**From:** Joanne Needham <joanne.needham@spab.org.uk>  
**Sent:** 27 January 2021 11:47  
**To:** Adrian Dowd; Planning  
**Subject:** Re: NC2/3/2020/0763 - Brabins Shop and Gallery, 20-22 Talbot Street, Chipping, Preston, Lancashire, PR3 2QE - SPAB Response

**Application ref: NC2/3/2020/0763**

**Address: Brabins Shop and Gallery, 20-22 Talbot Street, Chipping, Preston, Lancashire, PR3 2QE**

**Proposal: Application for listed building consent to undertake works to the building, insertion of replacement windows (like for like), replacement of roof coverings and the erection of new rainwater goods.**

Title: **FLOOR PLANS AND SECTIONS PROPOSED LAYOUT**

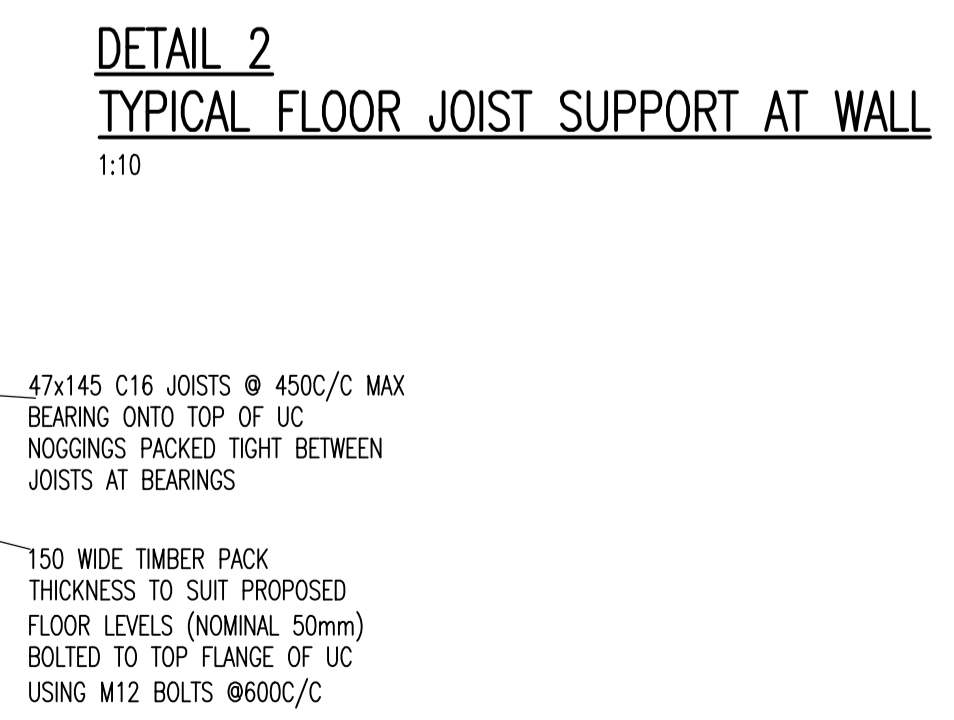
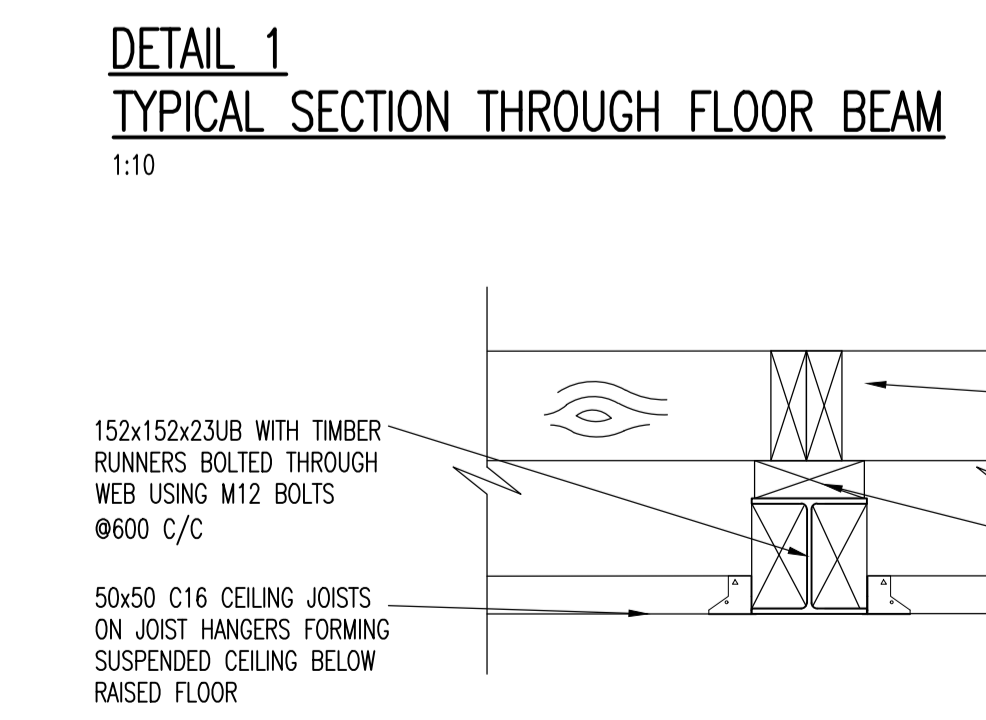
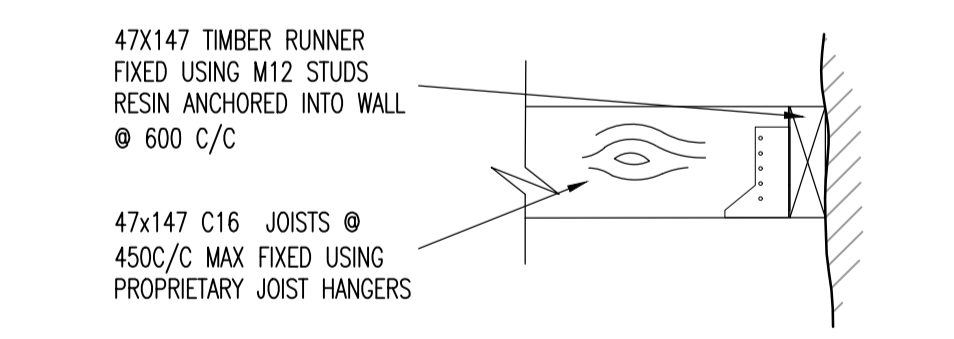
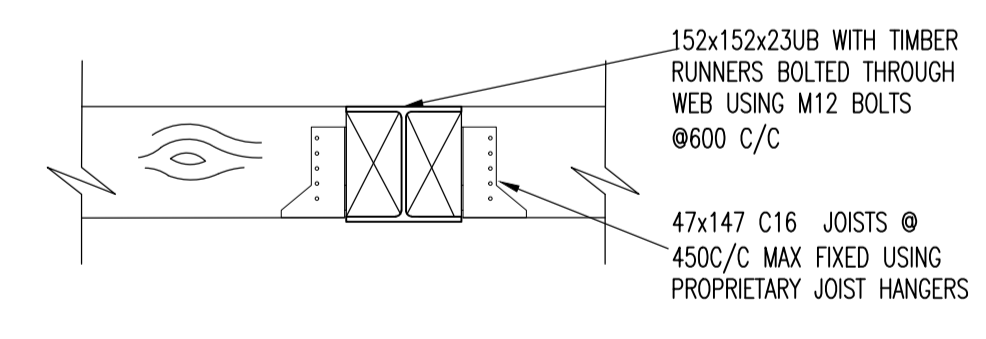
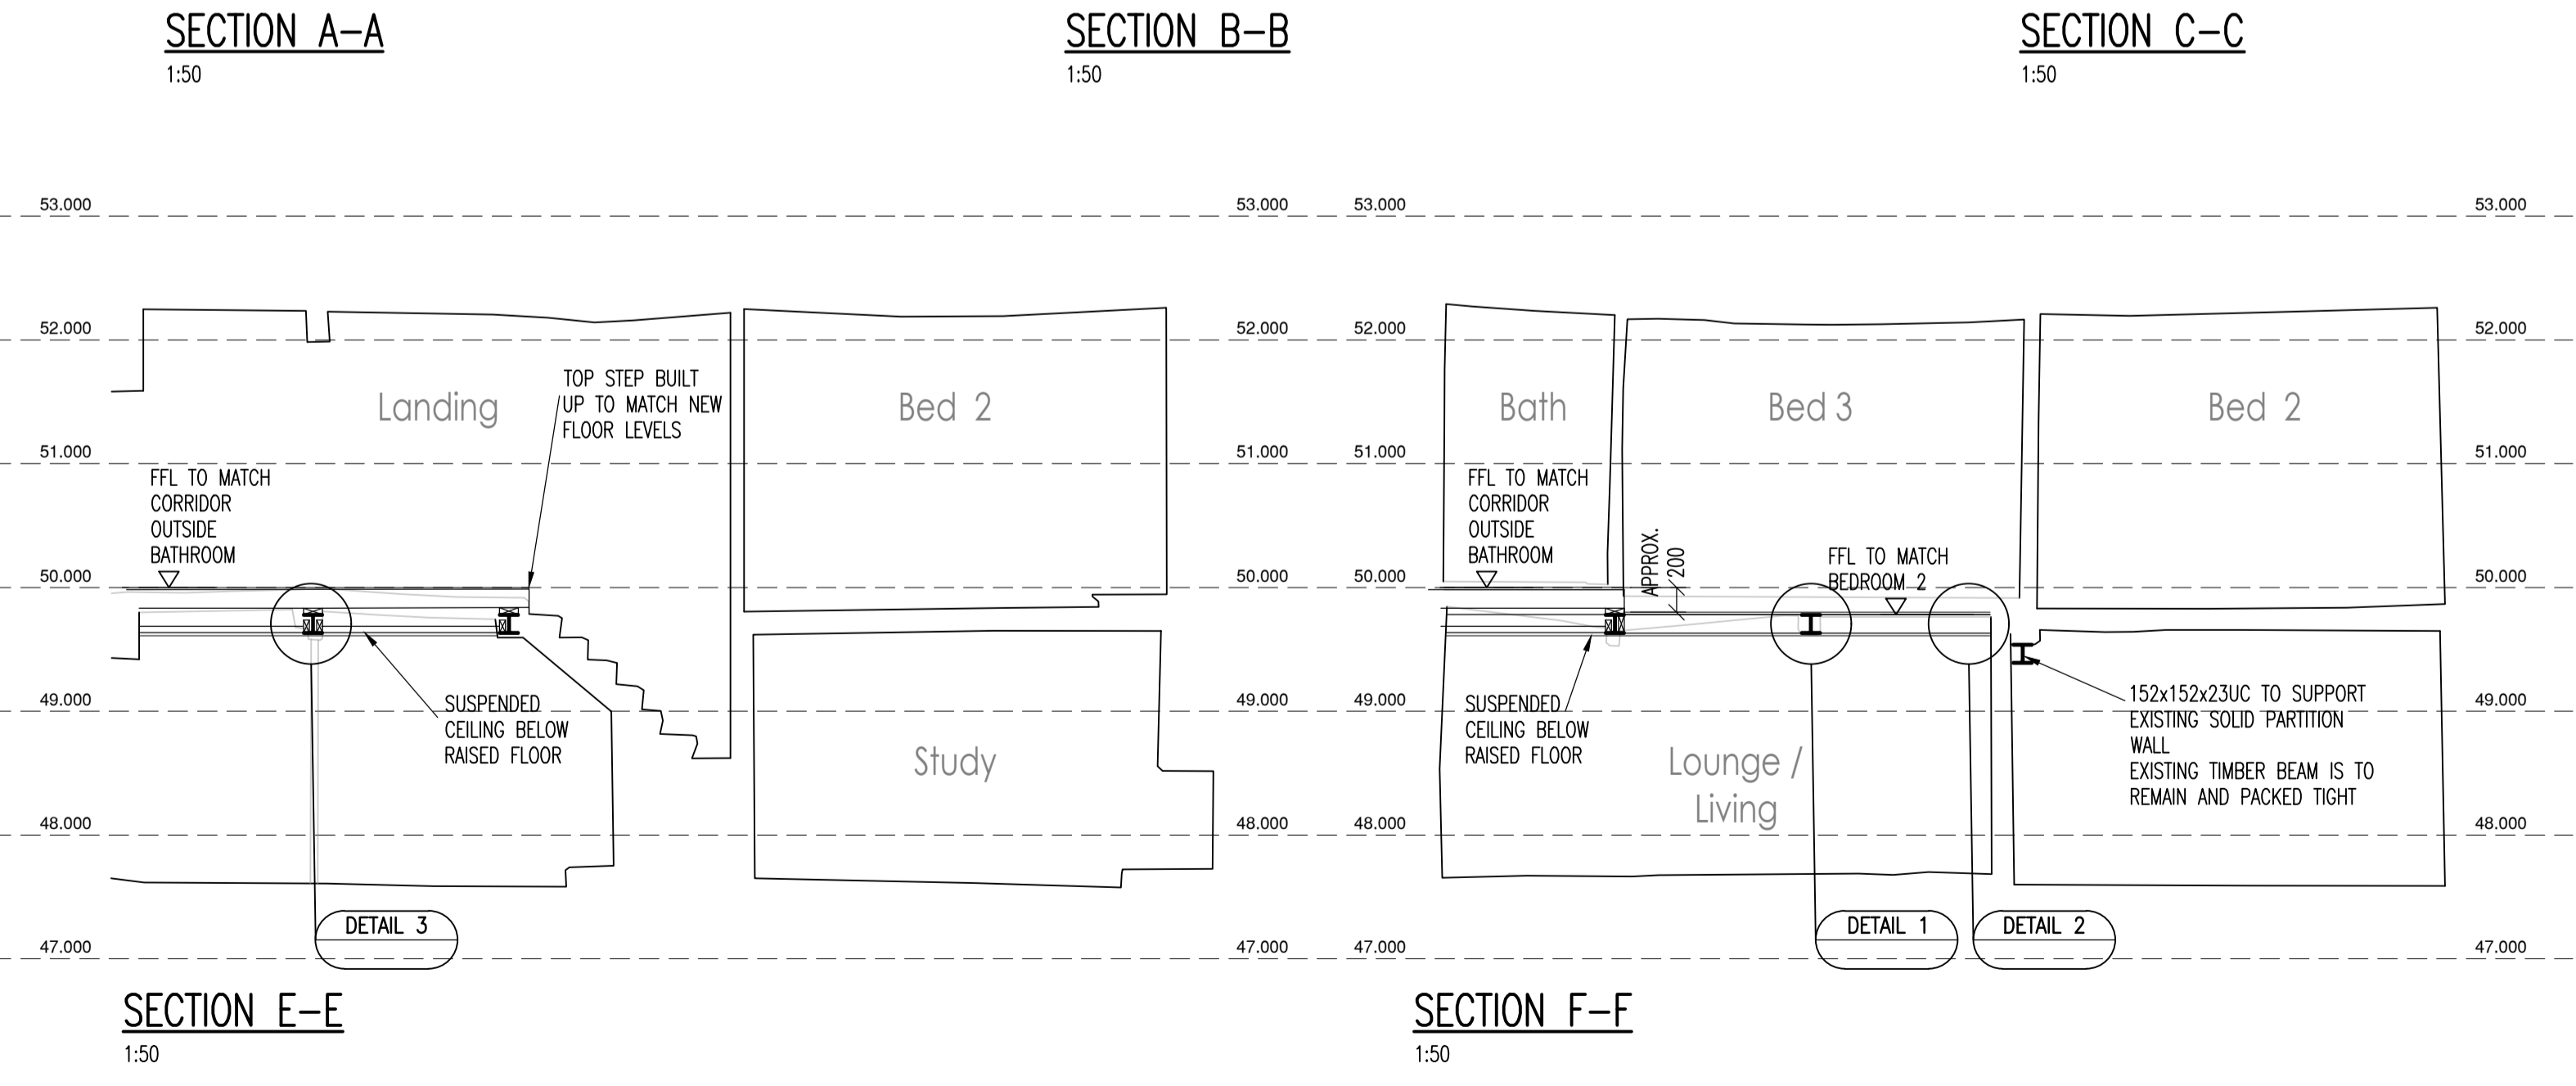
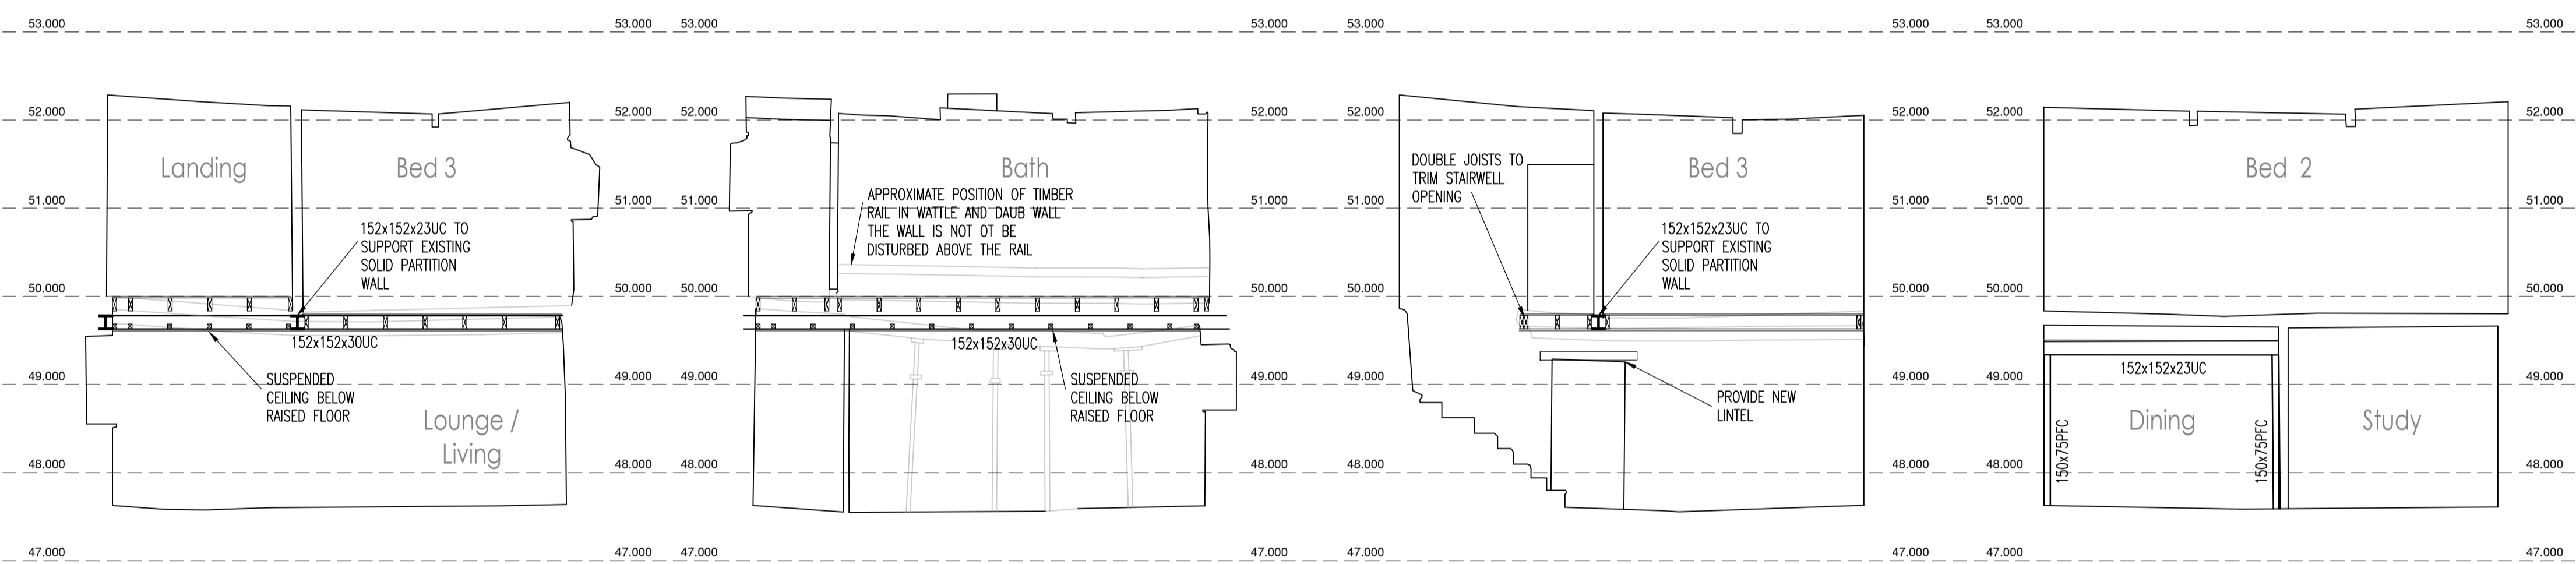
The proposed works would be a significant intervention that would, unintentionally, result in considerable harm and loss. The structural failure is clear, and we do not question the need for intervention, we wonder however if a less harmful solution is possible.

From the information provided, we believe that the option of a bespoke vertical steel splice (installed from the underside) to strengthen and repair the existing beam (and gently raising the beam to straighten it out slightly) may be possible (and may be possible with minimal disruption). A similar repair might also be possible to the dining room beam. We strongly encourage that these options be fully explored.

We also strongly encourage significantly reducing the loadings on the first floor (including the removal of the very heavy water tank). These additional/increased loads appear to have been a factor in the failure of the floor which has survived some considerable time.

Notwithstanding the above, it is perhaps also worth noting that we also do not support the approach to clad and decorate modern interventions (in this case - the steel beams) to mimic the historic beams.
